## MEMORANDUM

**RE:** Request for Certificate of Occupancy  
137 Webb Street (262-B-020)

On February 9, 1998 the site was reviewed for compliance with the conditions of approval dated 10/31/97; my comments are:

AS-BUILT PLAN
PER COFO LETTER

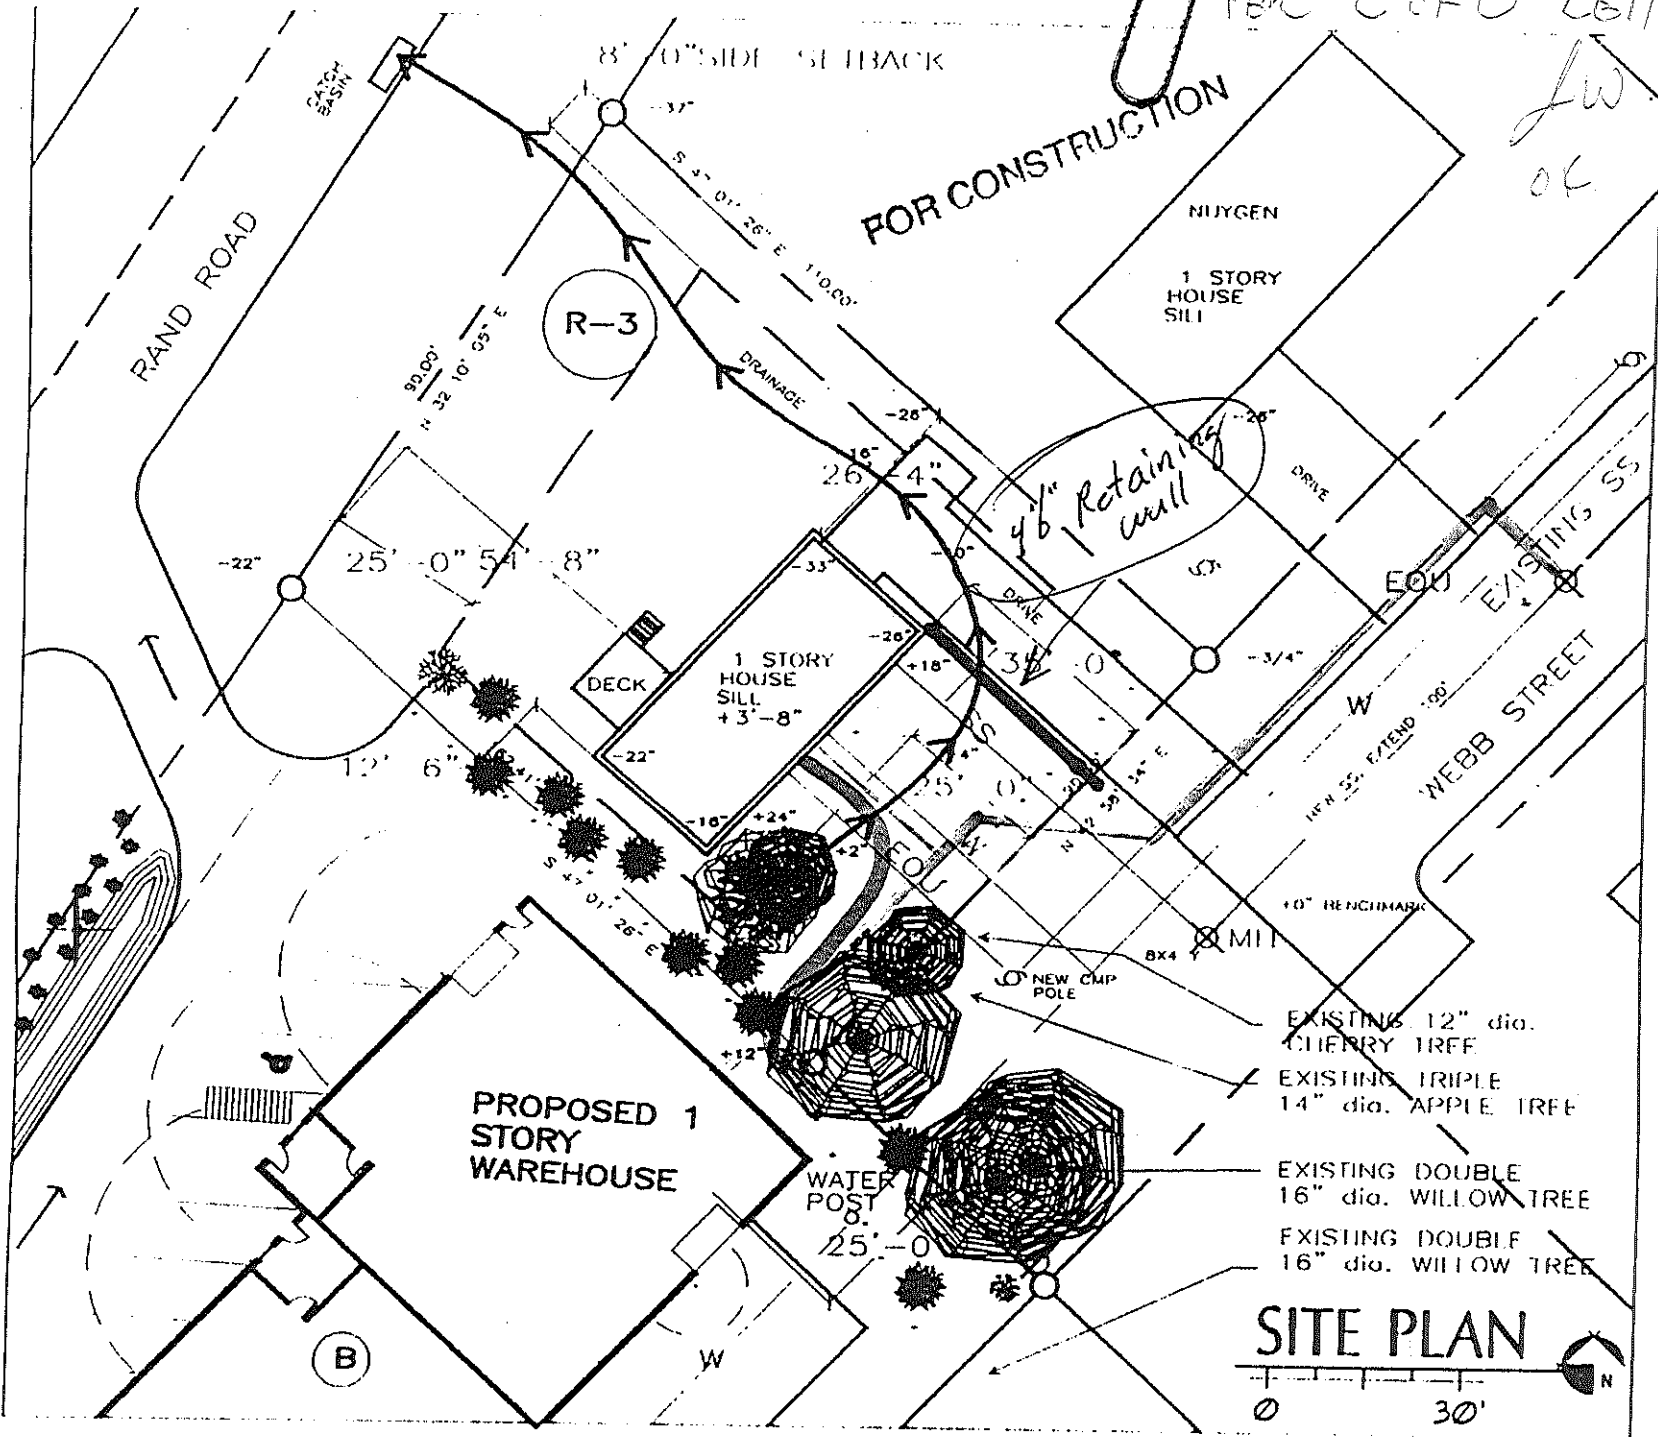
4. The original approval required a boundary survey; also a medium high retaining wall has been installed and the location of the services has changed. Therefore an "asbuilt" site plan must be submitted to the DRC showing the actual locations of the house relative to the property line based on the boundary survey, the utility services(i.e. sewer, water, storm and electric) and the retaining wall. The plan shall include the boundary survey information and the surveyor's stamp.
